Your ref:
Our ref: 24/00624/F
Please ask for: Charlie Collier
Direct dial:
E-mail: borough.planning@west-norfolk.gov.uk

10 April 2024

Details: **To renovate and extend the present garage to form a living area and to add an upper floor extension to form a new master bedroom and en-suite at 19 Avon Road South Wootton King's Lynn Norfolk PE30 3LS**

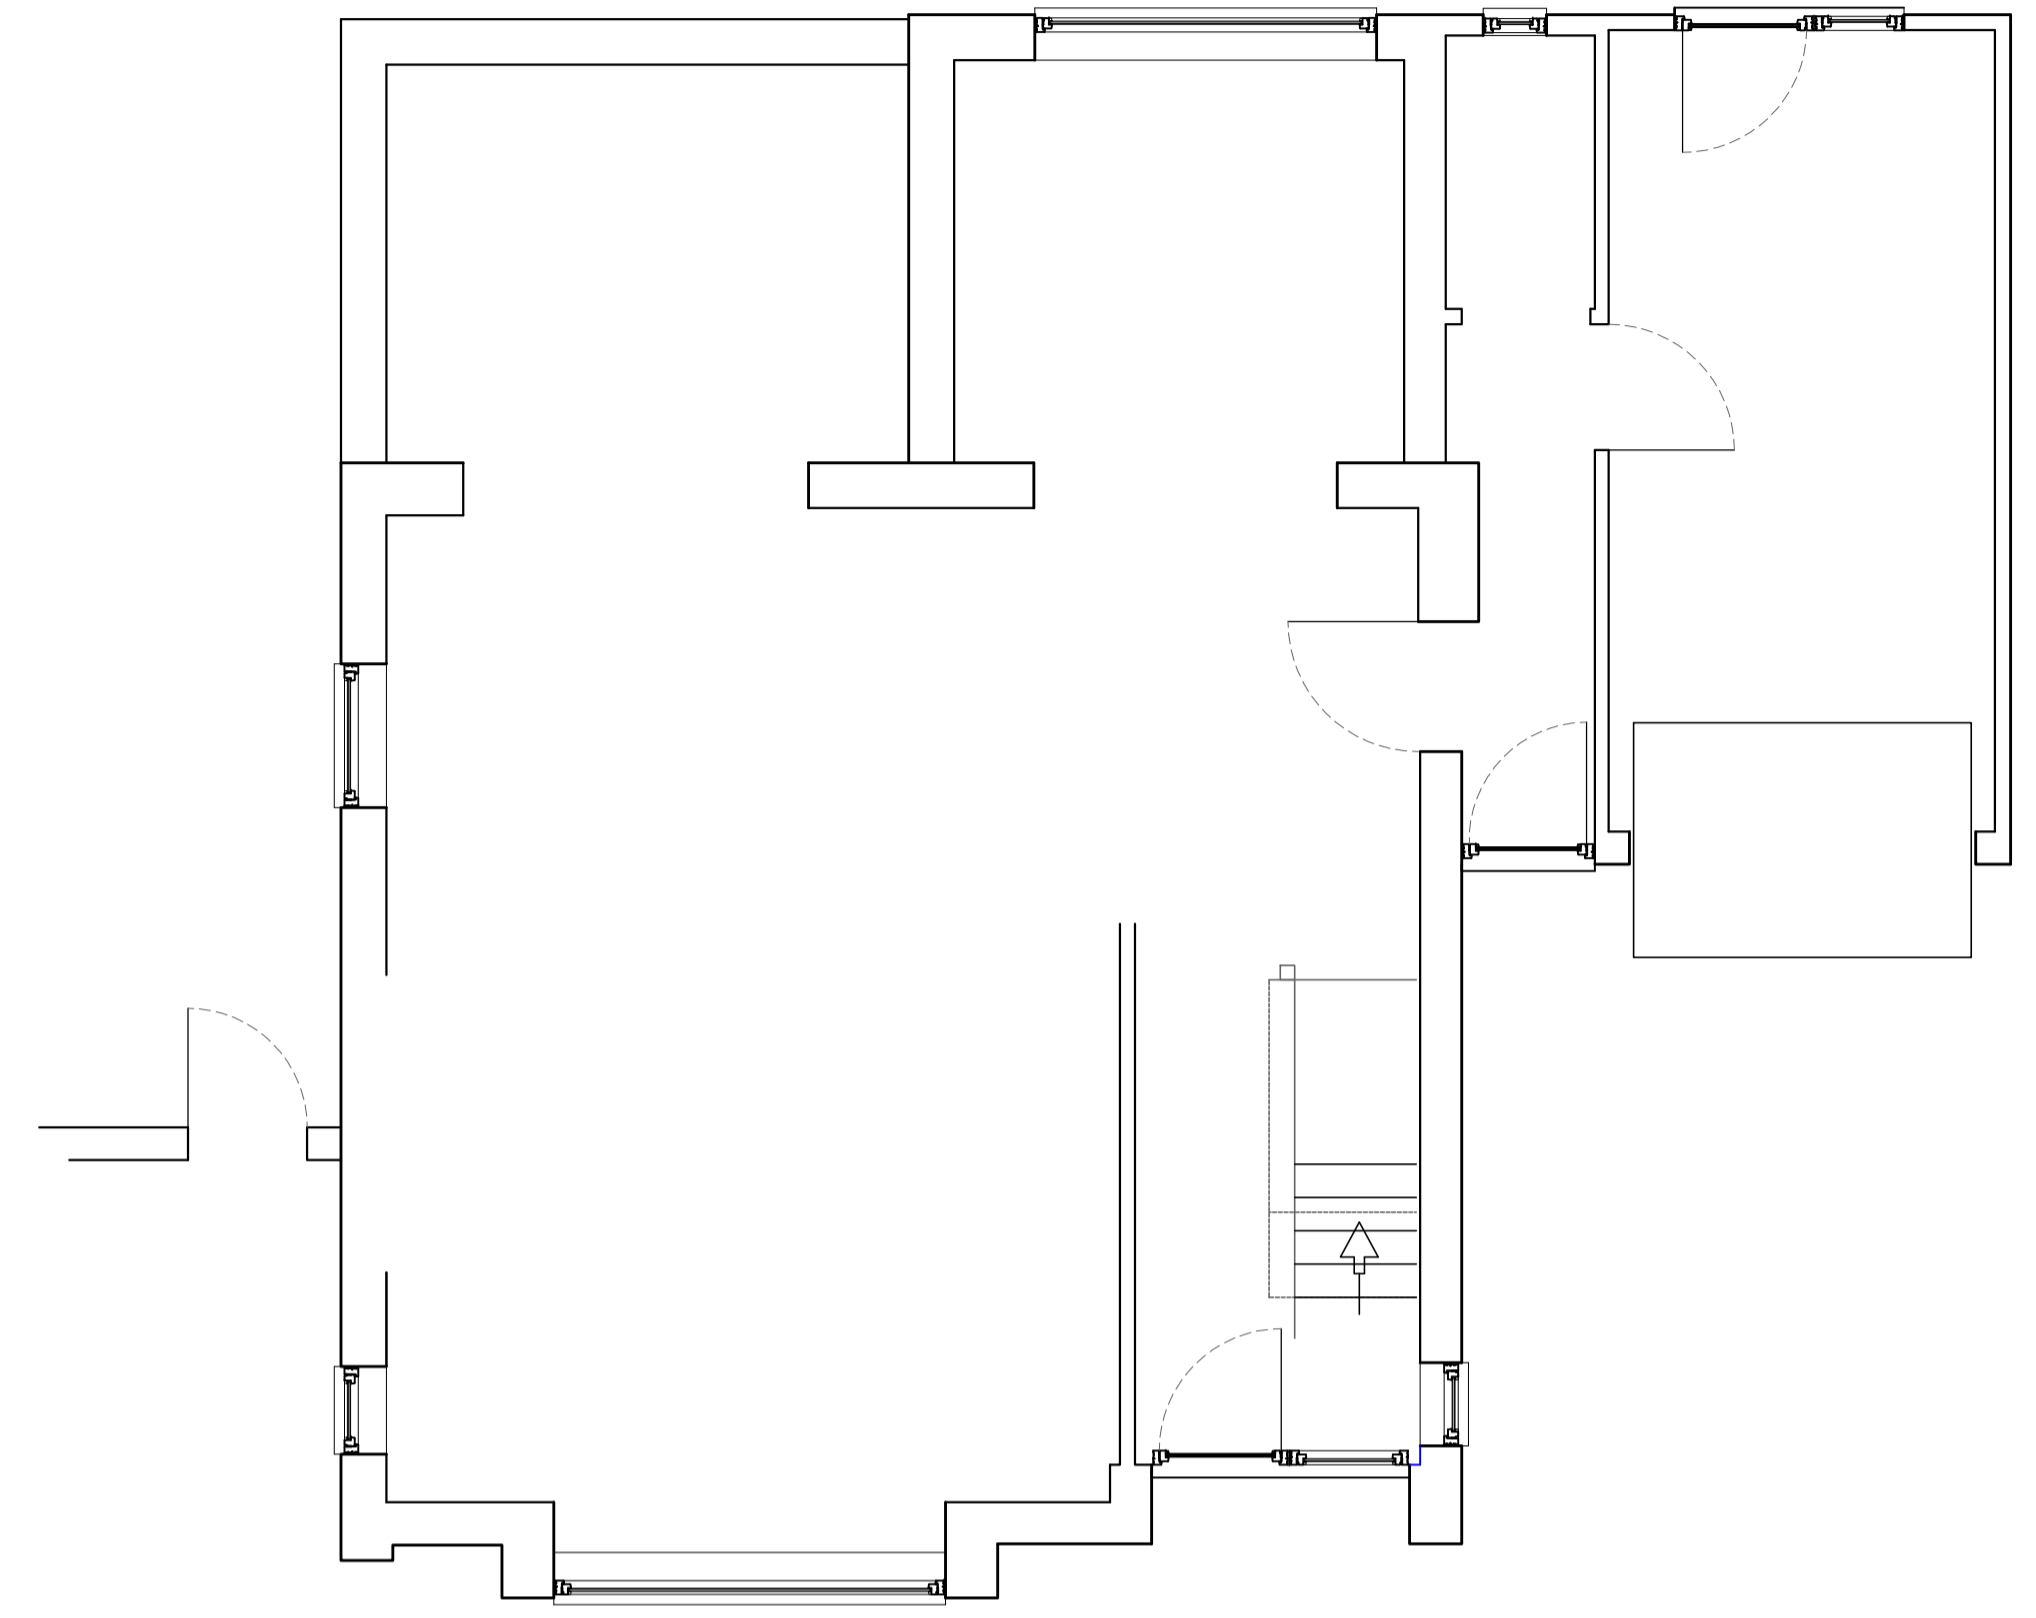
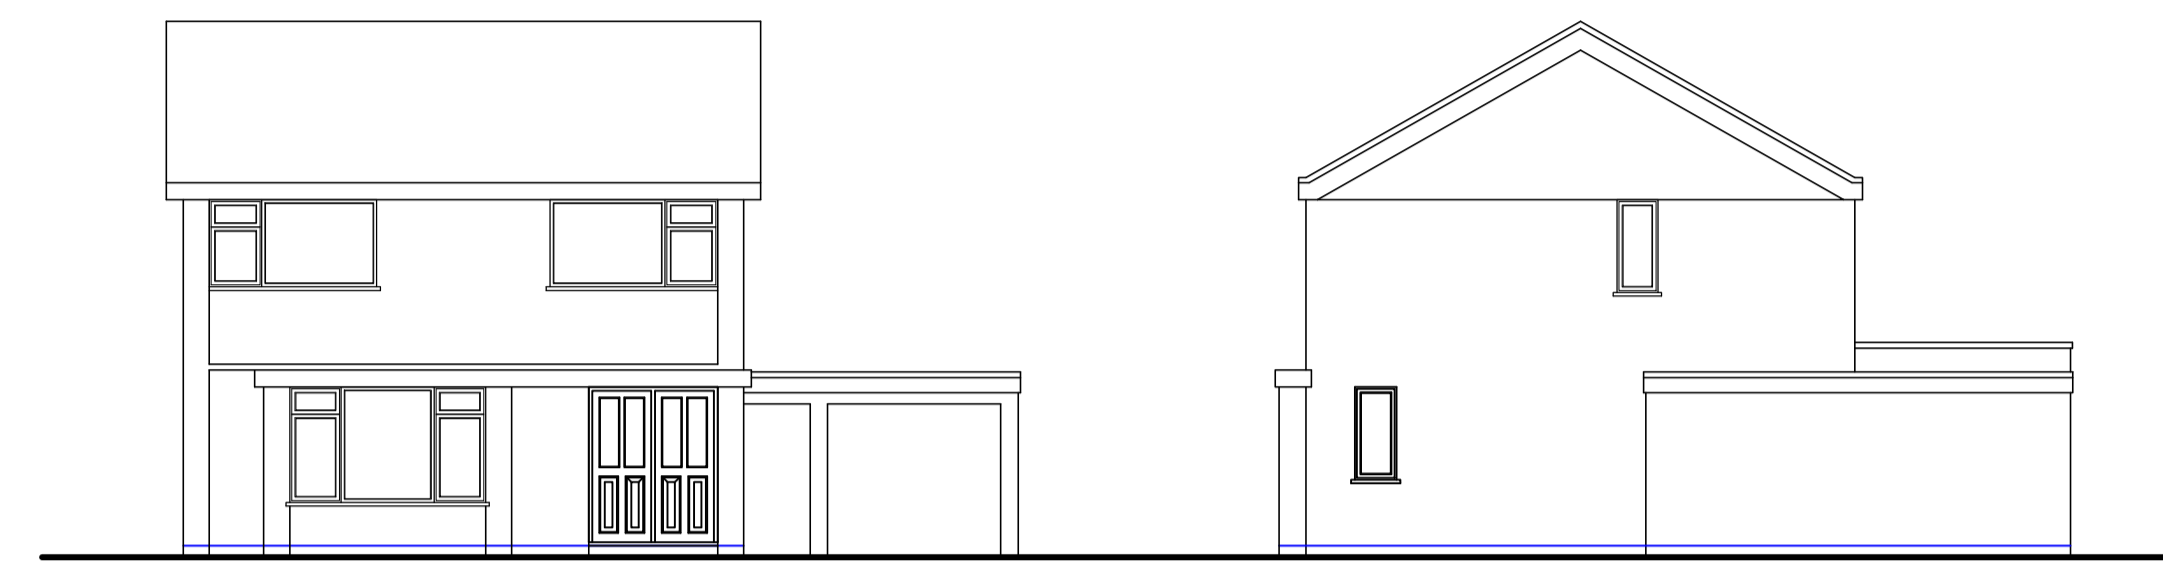
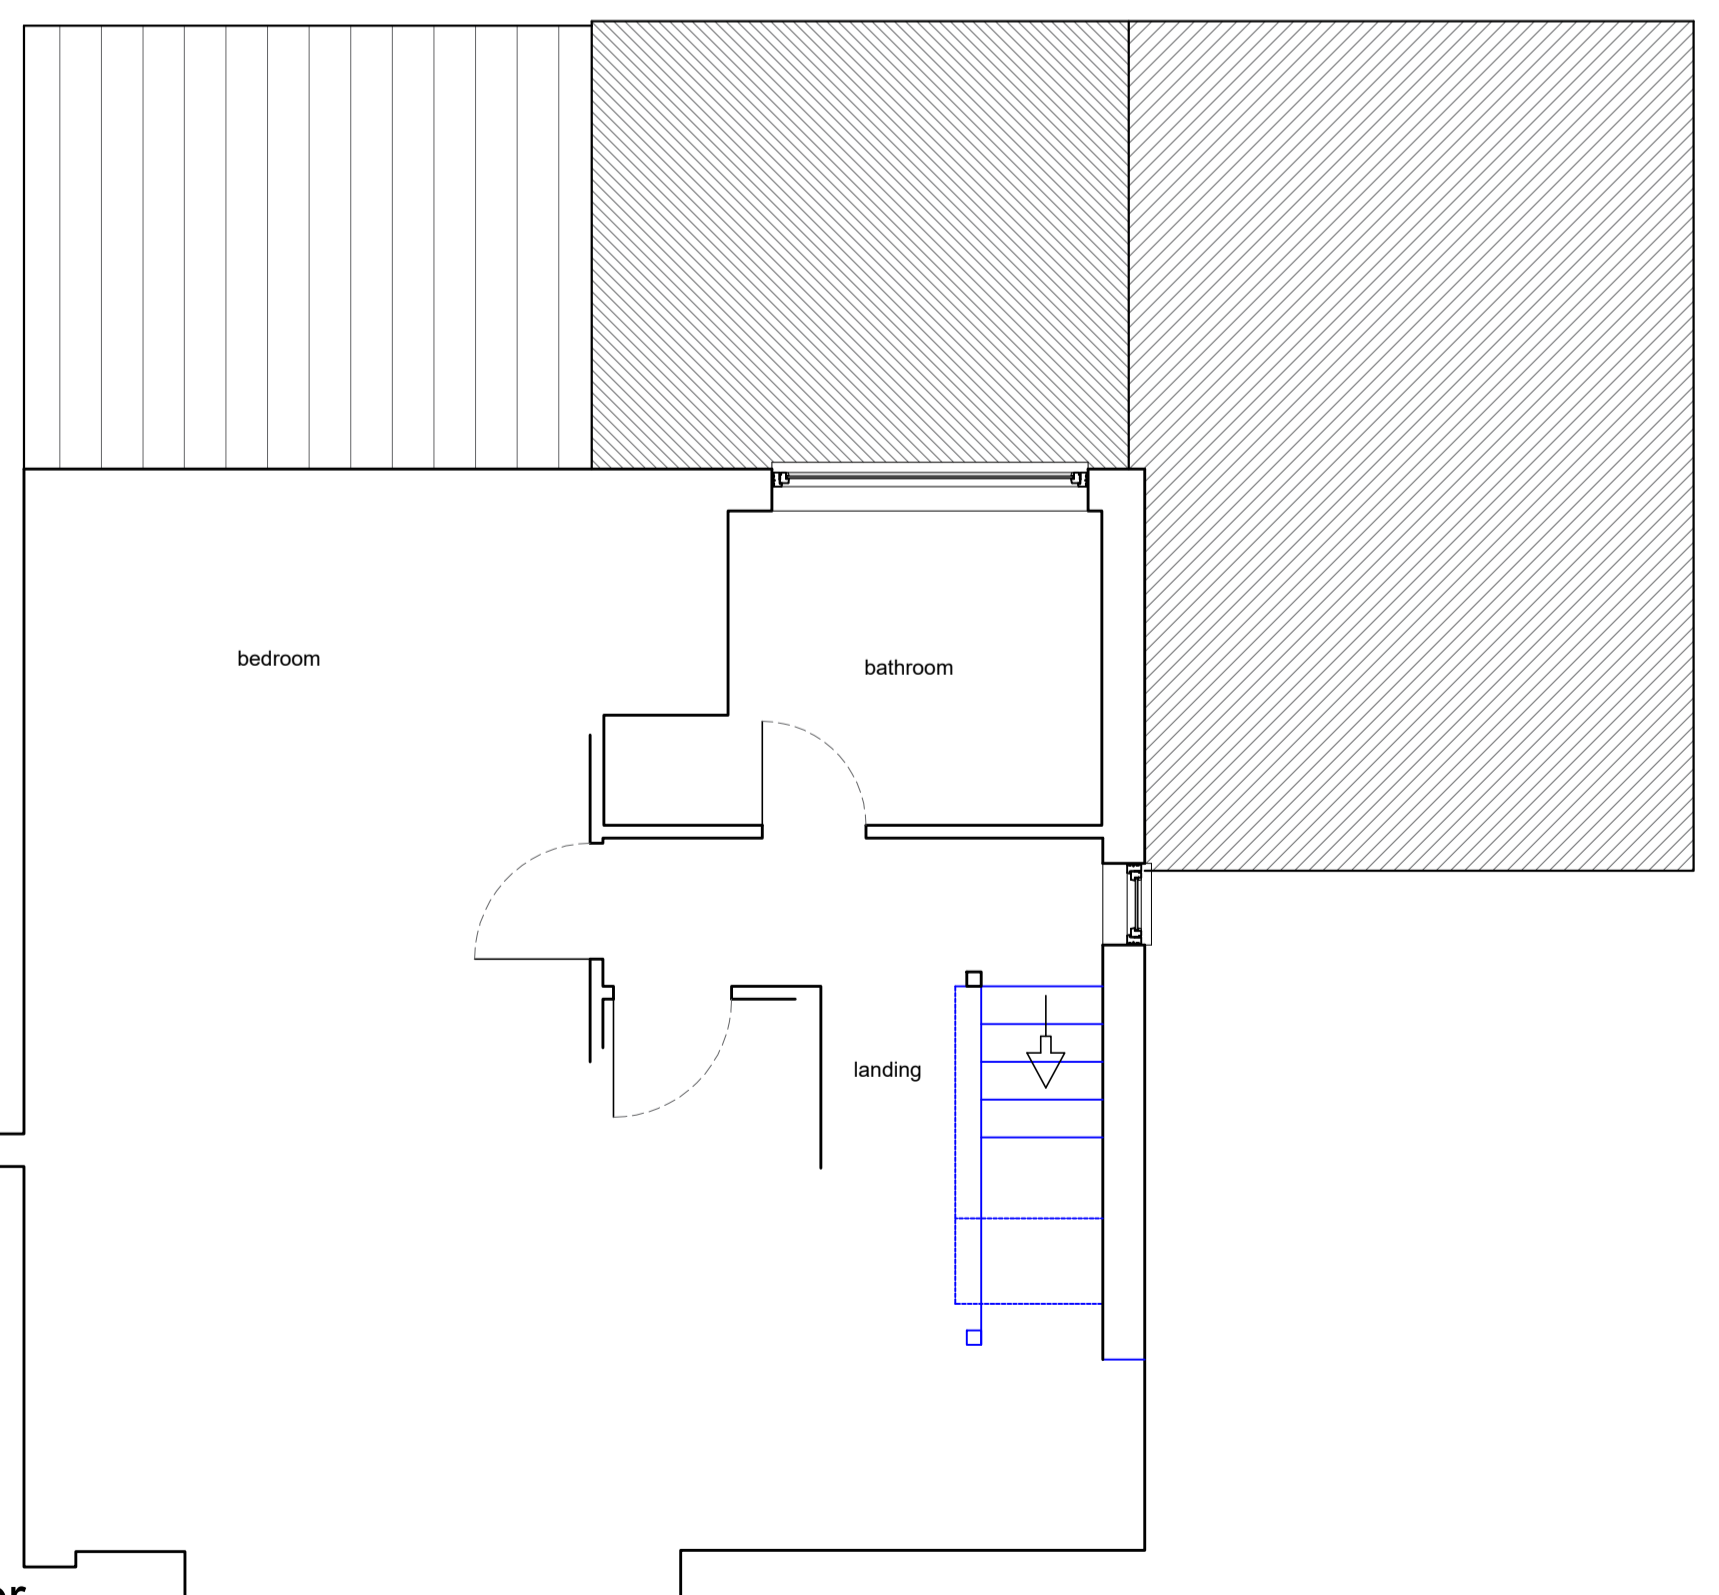
1. Please amend proposed plan to include annotations on elevations.
2. Please amend both proposed and existing floorplans to match elevations.
